Subject: FW: Planning applications 3/2015/0367 & 0369

Subject: Planning applications 3/2015/0367 & 0369

S.J. Bialecki Limited Building Surveyors
Drawing no 6008
Scale 1:50
Proposed Elevations
Proposed Two Storey Extensions At 8-9 West View Grindleton

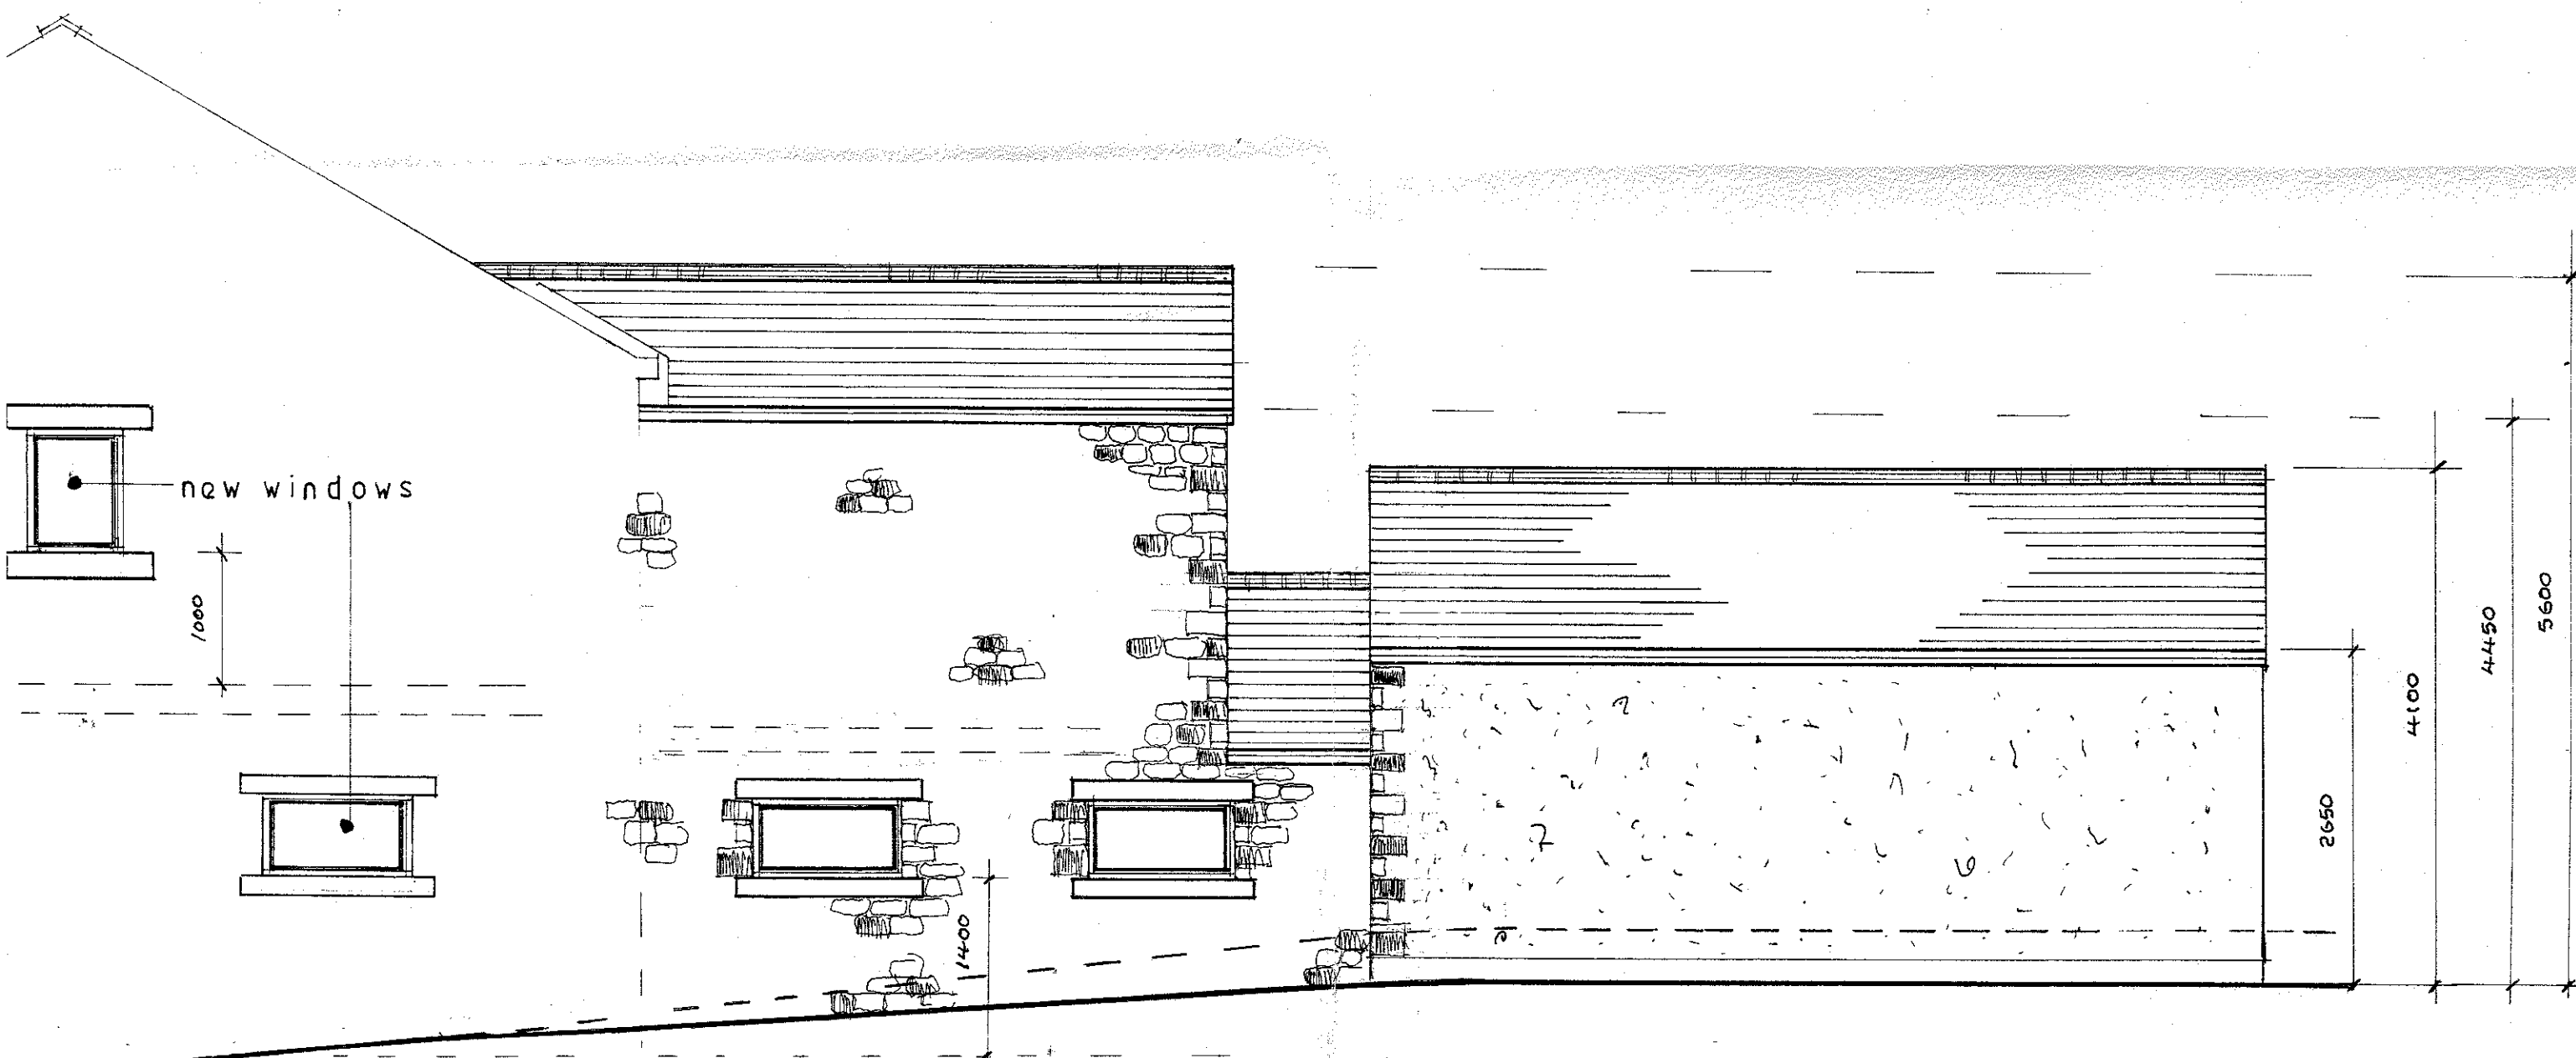
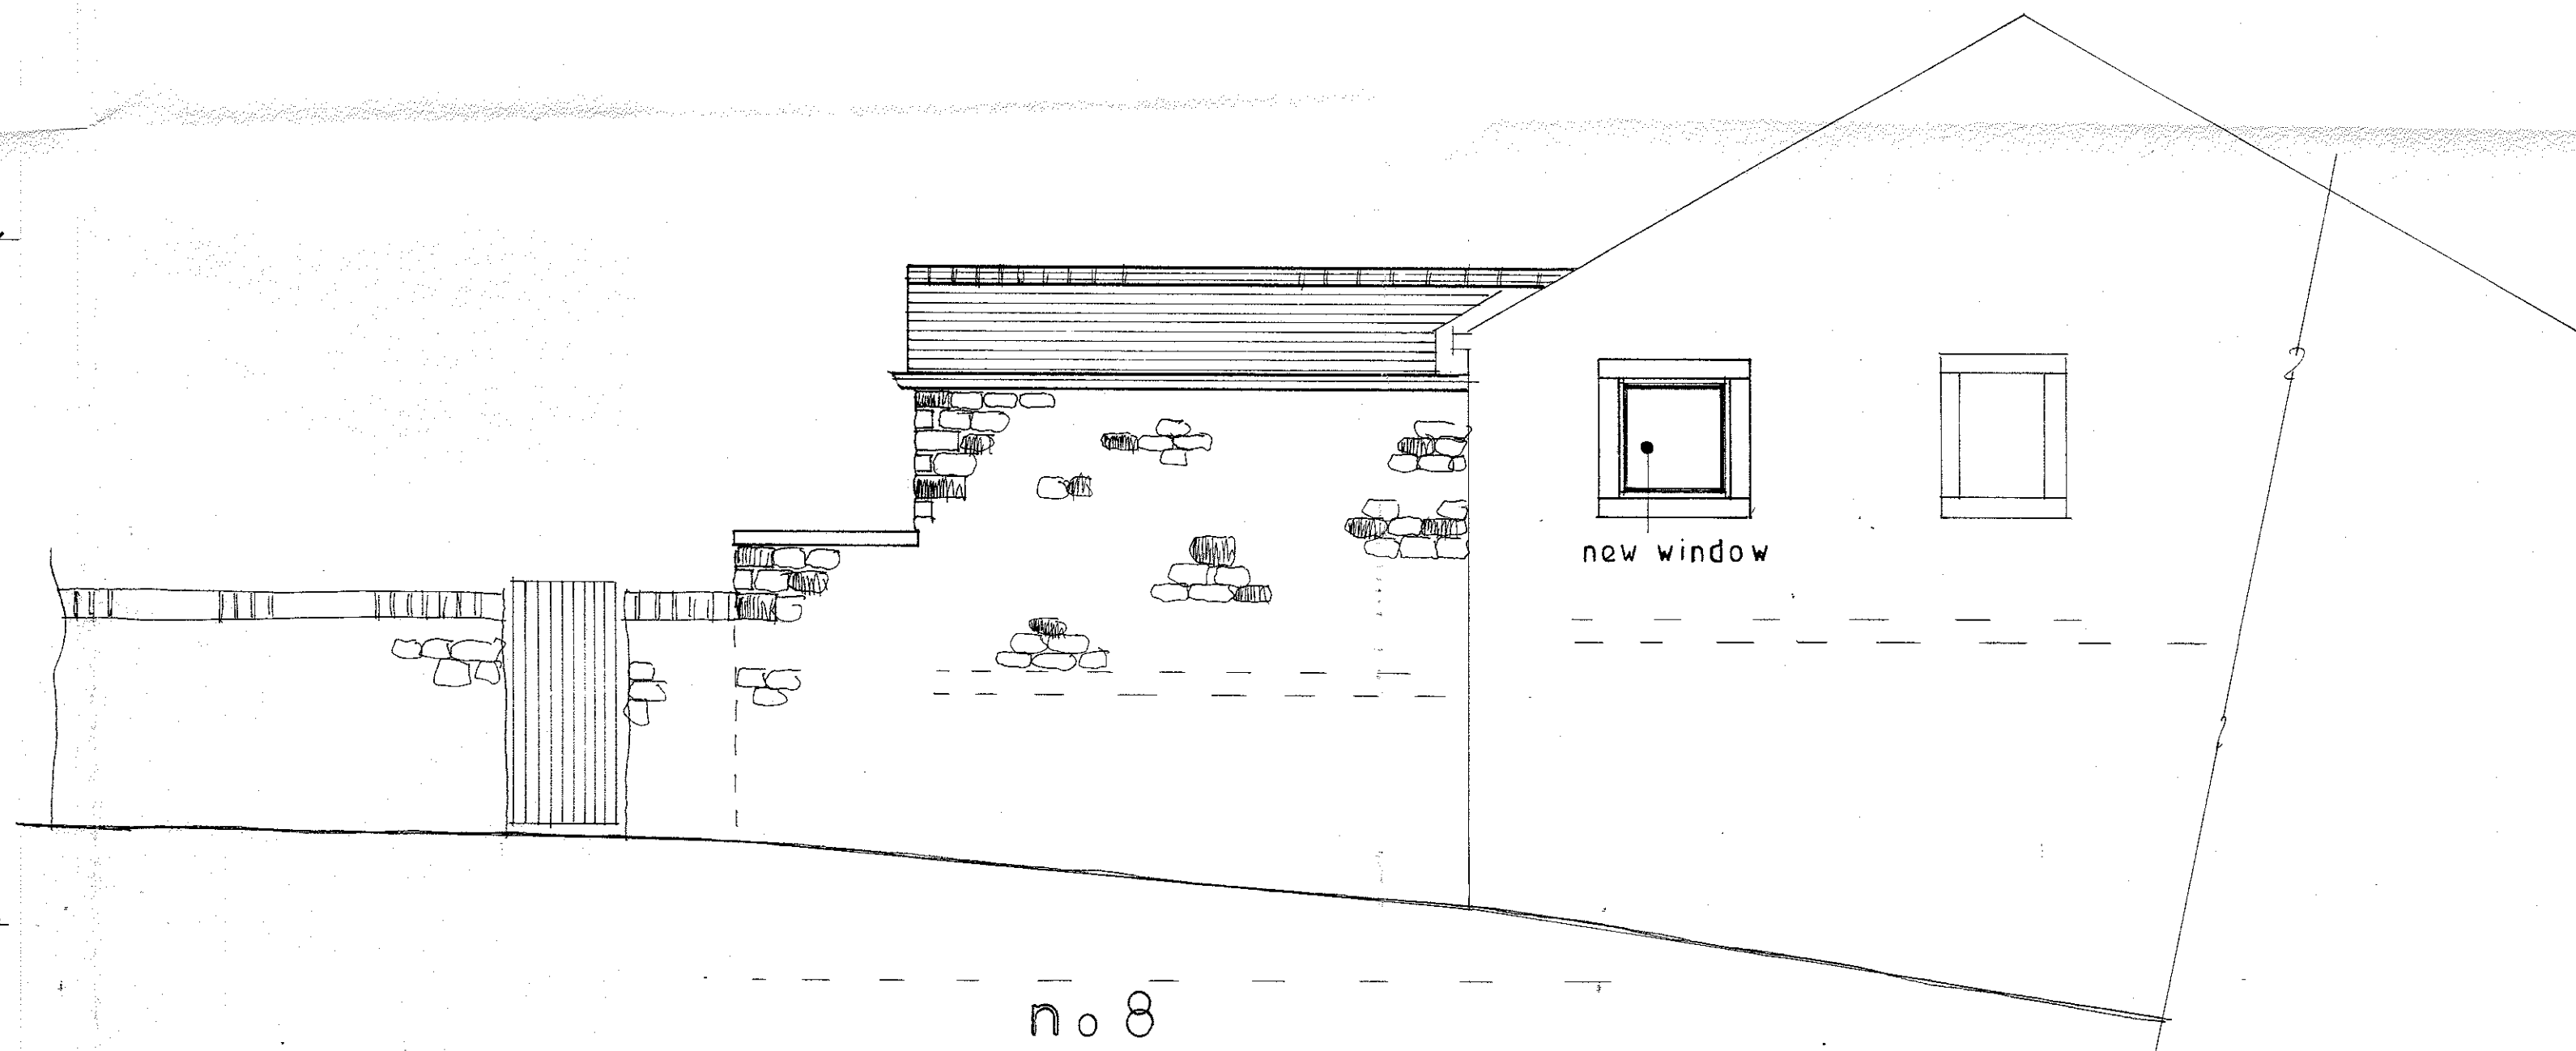
Our parish council has no issue in principle with the above applications, other than that of the provision of windows on the north and south elevations. We feel that they may be an intrusion into the privacy of the adjacent neighbours. Roof lights would serve the same purpose as the proposed windows, especially on the north elevation.
